CITY OF MERCER ISLAND

October 19, 2022

RE: Incomplete resubmittal - Request for Information #2. Milestone Short Subdivision: File Nos. SUB21-006, CAO21-004, SEP21-022. Location: 7621 SE 22nd ST, Mercer Island, WA 98040; King County Tax Parcel # 531510-1846

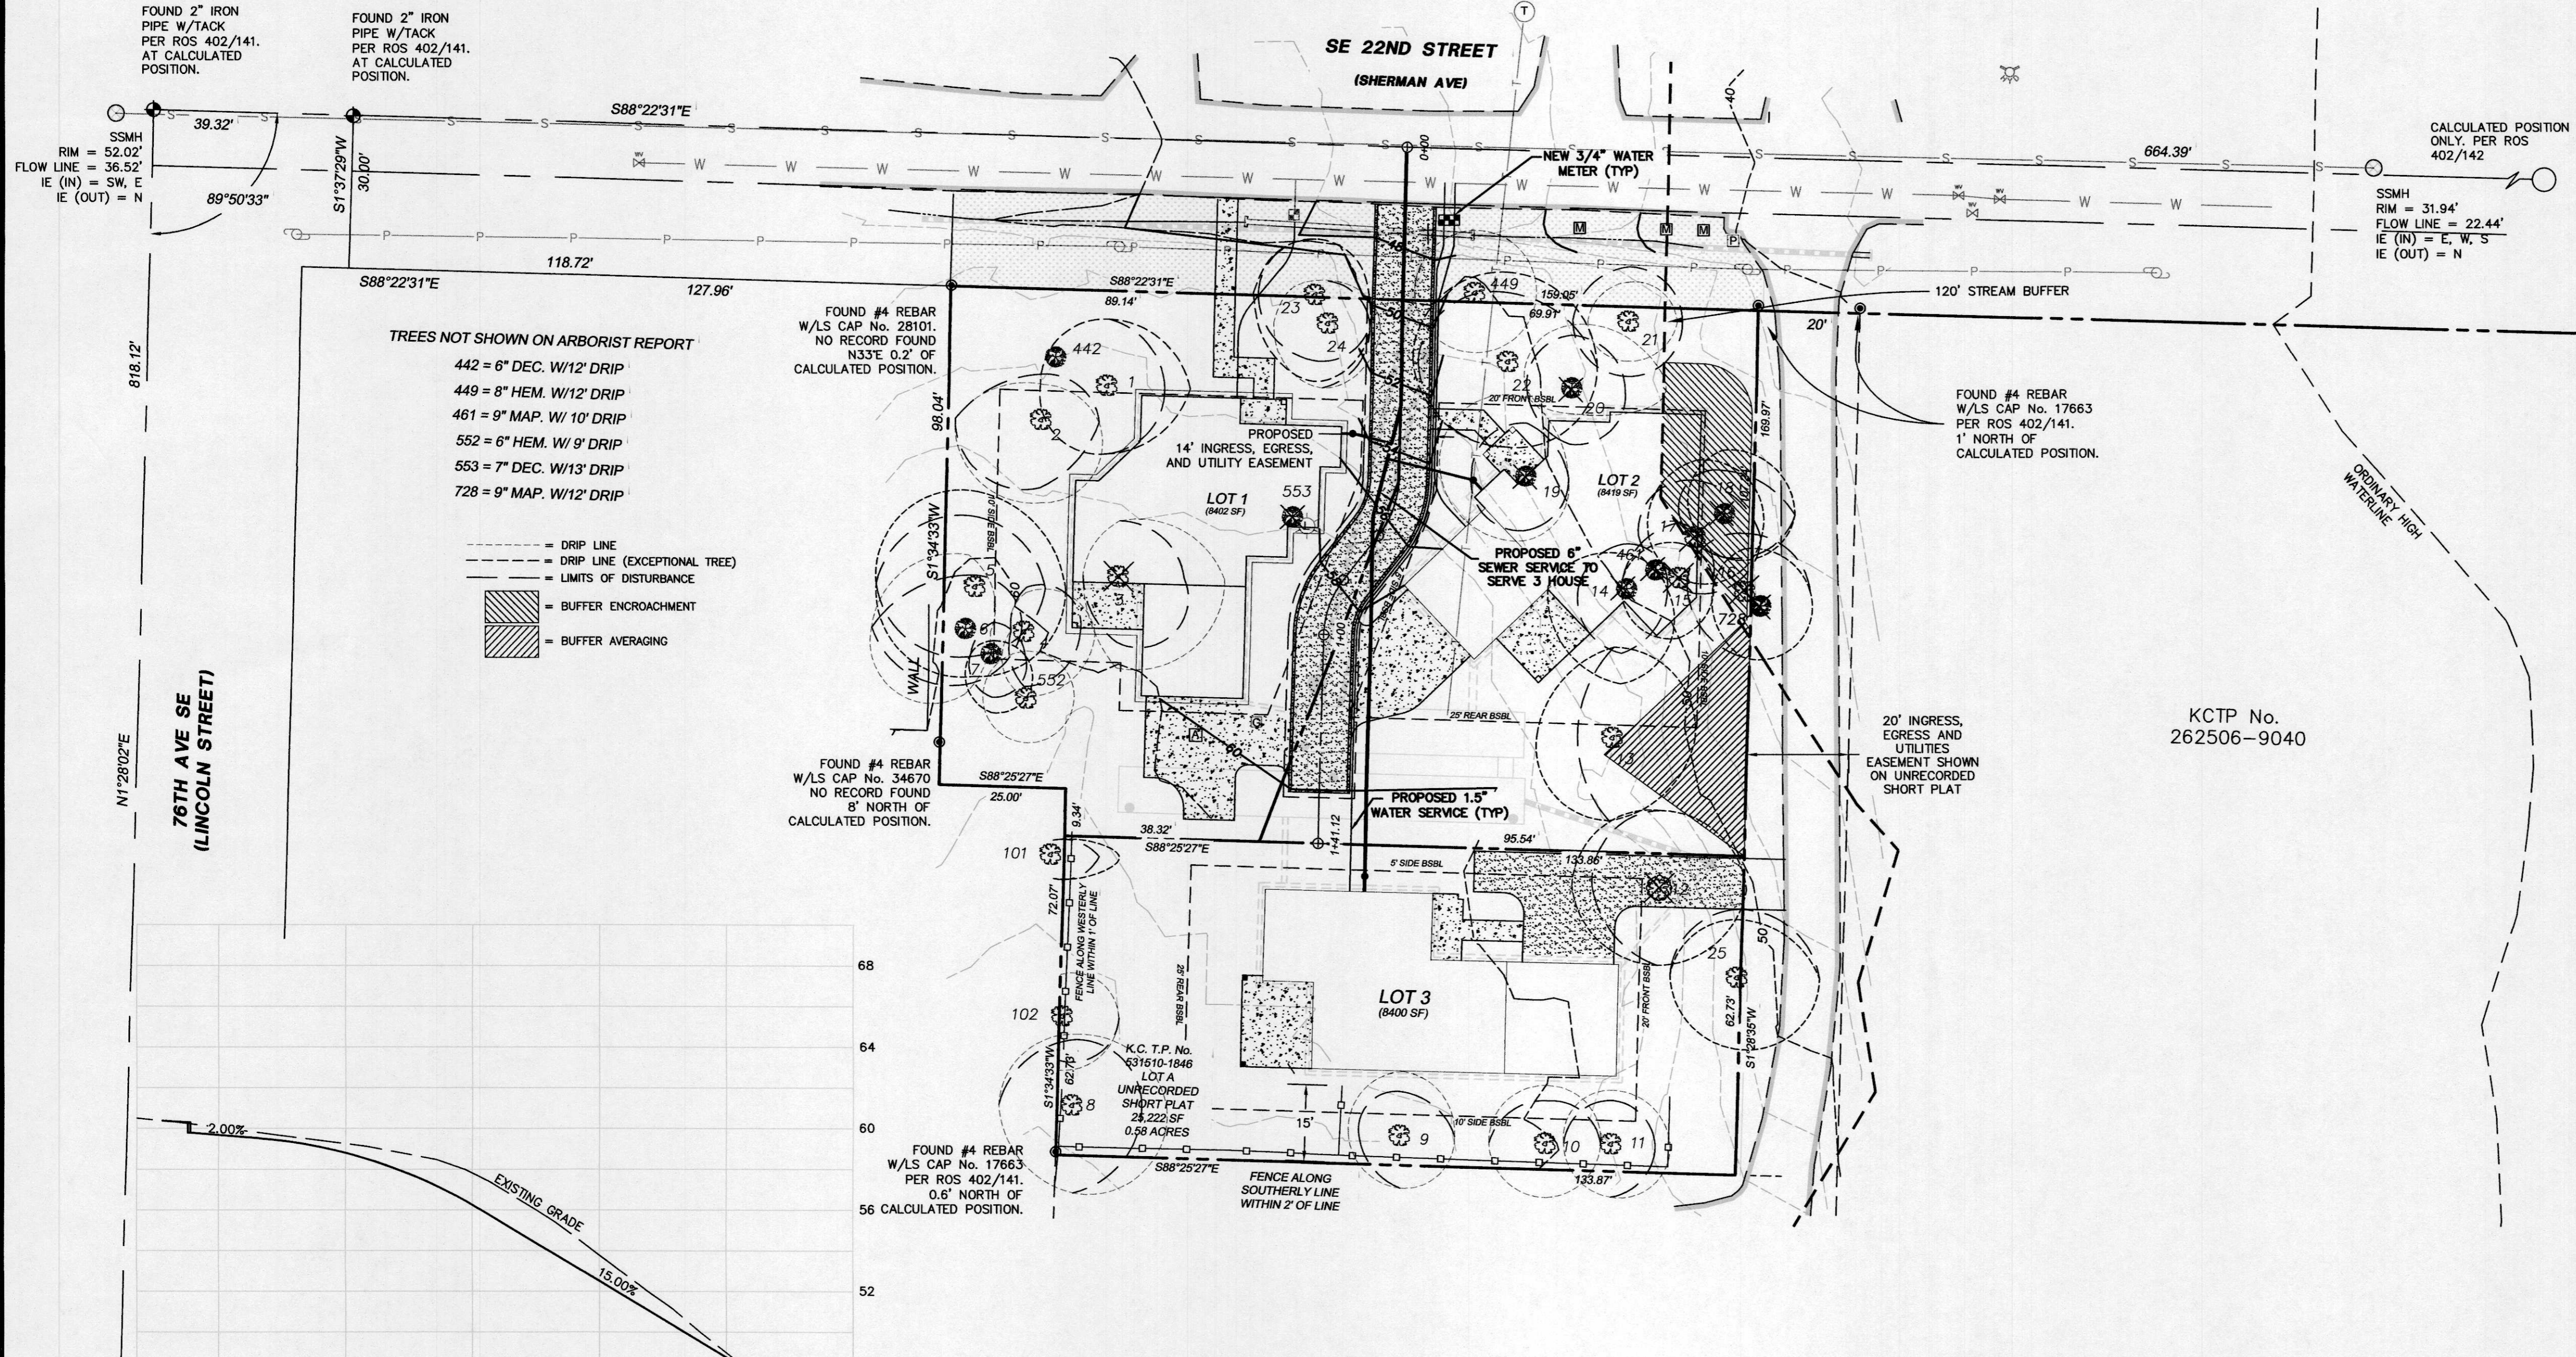
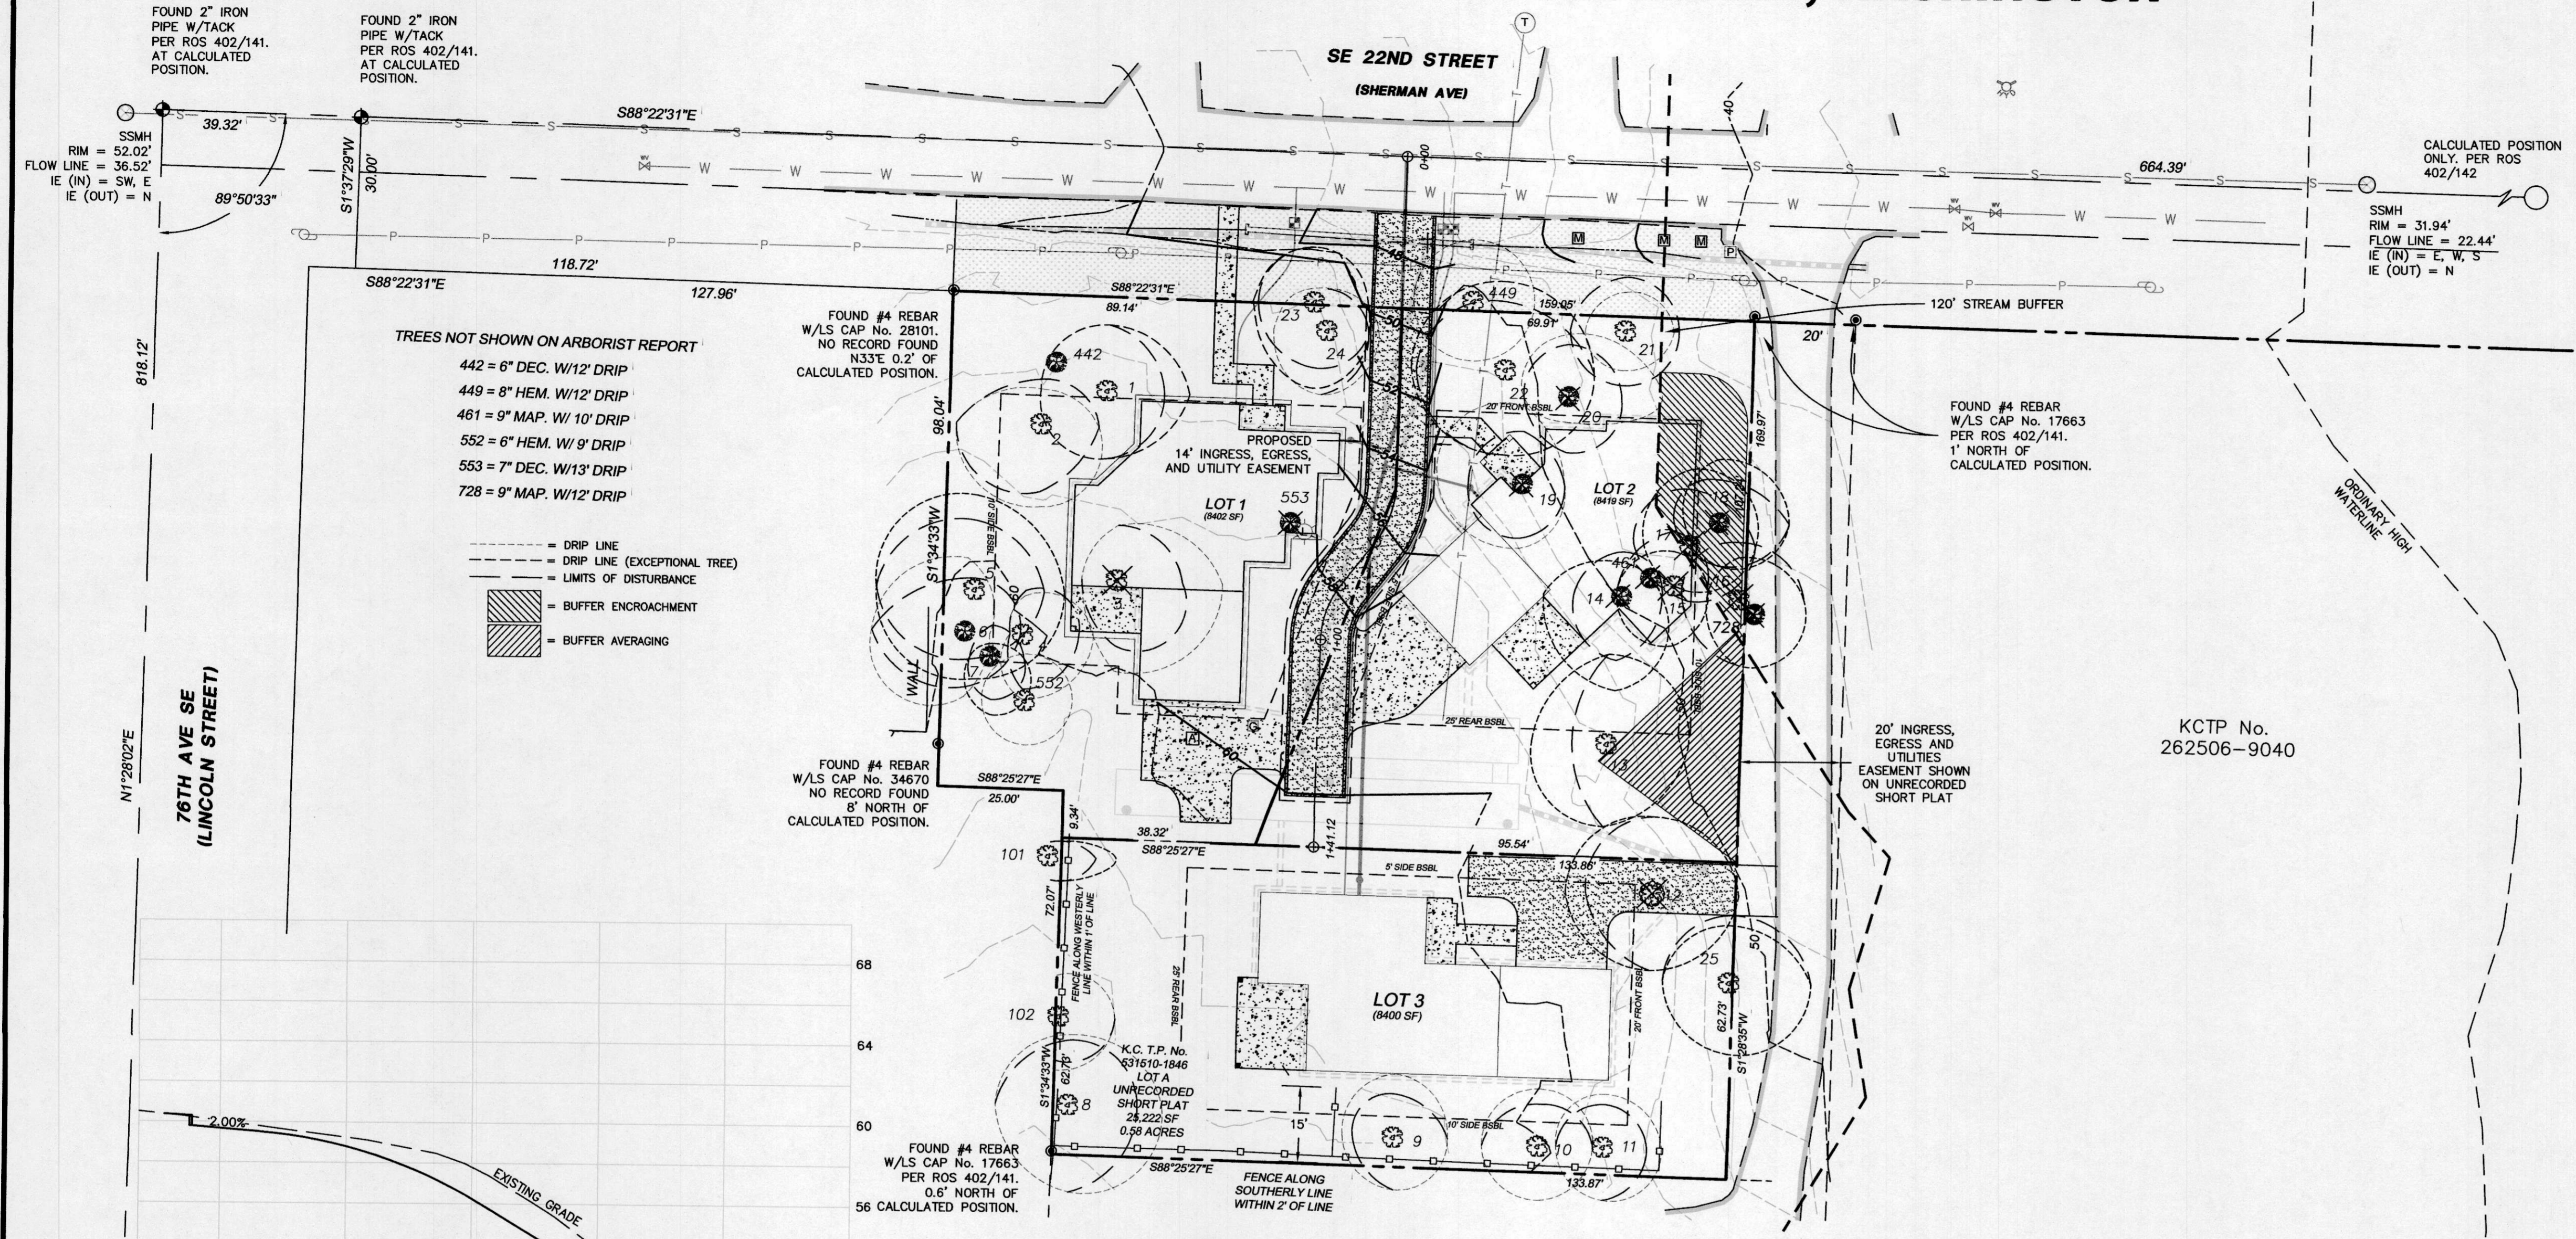
1. Provide an updated critical area report that addresses the impacts to the critical area buffer from the improvements to the private access driveway serving lot 3 and the adjacent property. Follow the mitigation sequencing in MICC 19.07.100. Additionally, the critical area report needs to be modified to remove any discussions regarding setback reductions if the reduction is no longer applicable.
2. The plan set does not show the proposed improvements to the private access driveway serving lot 3 and the adjacent property. The proposed improvements and mitigation for impacts to critical areas must be illustrated on the plan set.
